**Byers Gill Solar – EN010139**

**Section 51 advice regarding draft application documents submitted by JBM Solar**

Rev
DRAFT

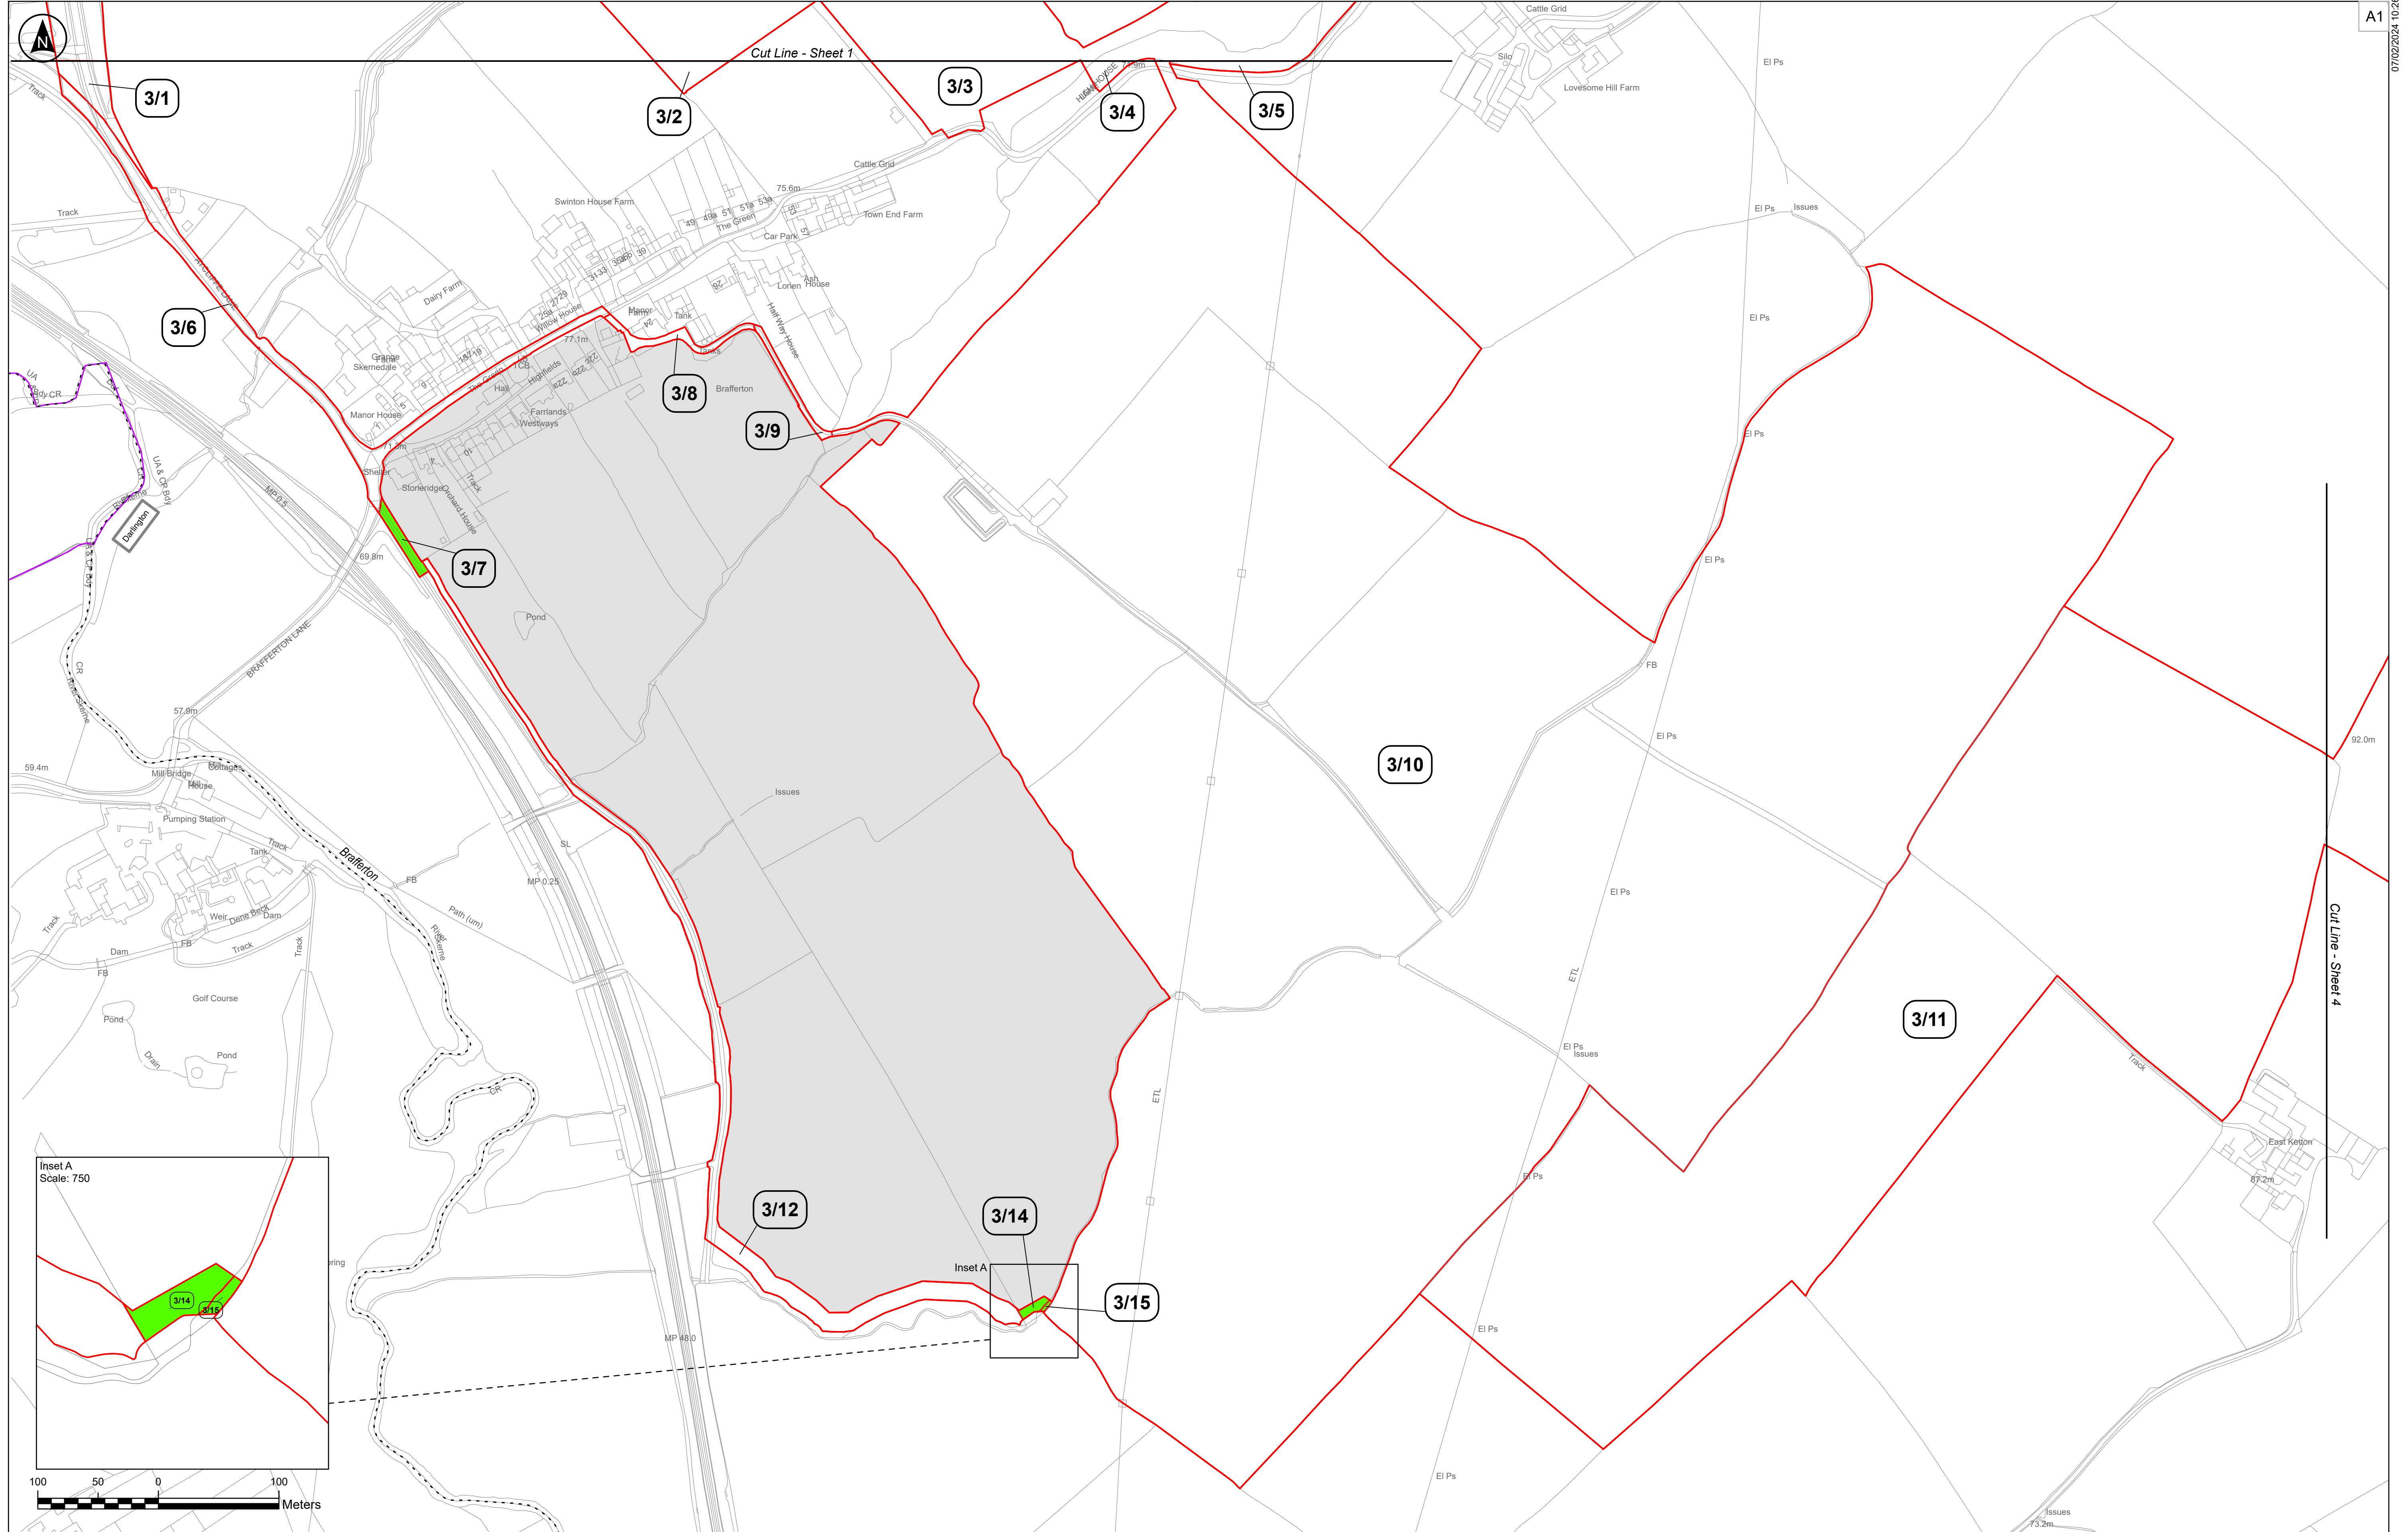
19.	<b>Key plan and Sheets 1-13</b>	It is noticed that both the overall key plan and the associated individual sheets state their scale as being 1:2500 at A1. The Land Plan Sheets and the Key Plan are clearly at different scales, and this brings into question the scale of the Land Plan and compliance with The Infrastructure Planning (Applications: Prescribed Forms and Procedure) Regulations 2009 (APFP 2009) Regulation 5 (4A). It appears likely the Key Plan is incorrect in its quoted scale. The Inspectorate would like to remind the Applicant that such inaccuracies reduce confidence that any or all stated information is accurate.

Land Plan		
Ref No.	Plan ref	Comment/Question
		The Applicant may wish to check the scales of the sheets of the plan provided and ensure that the scale is correctly stated on each sheet.
20.	<b>General and Part 5 of the dDCO</b>	<p>It has been noticed that the draft Development Consent Order refers to all land within the order limits being within the scope of Compulsory Acquisition powers, but this is not what is shown in the Land Plan, which most of the land appears to have been shaded in conformity with the legend entry for land that is not subject to compulsory acquisition. This could cause confusion as this does not appear to be consistent.</p> <p>The Applicant may wish to review this point and ensure that there is consistency between different documents and clarify the position in relation to Compulsory Acquisition powers.</p>
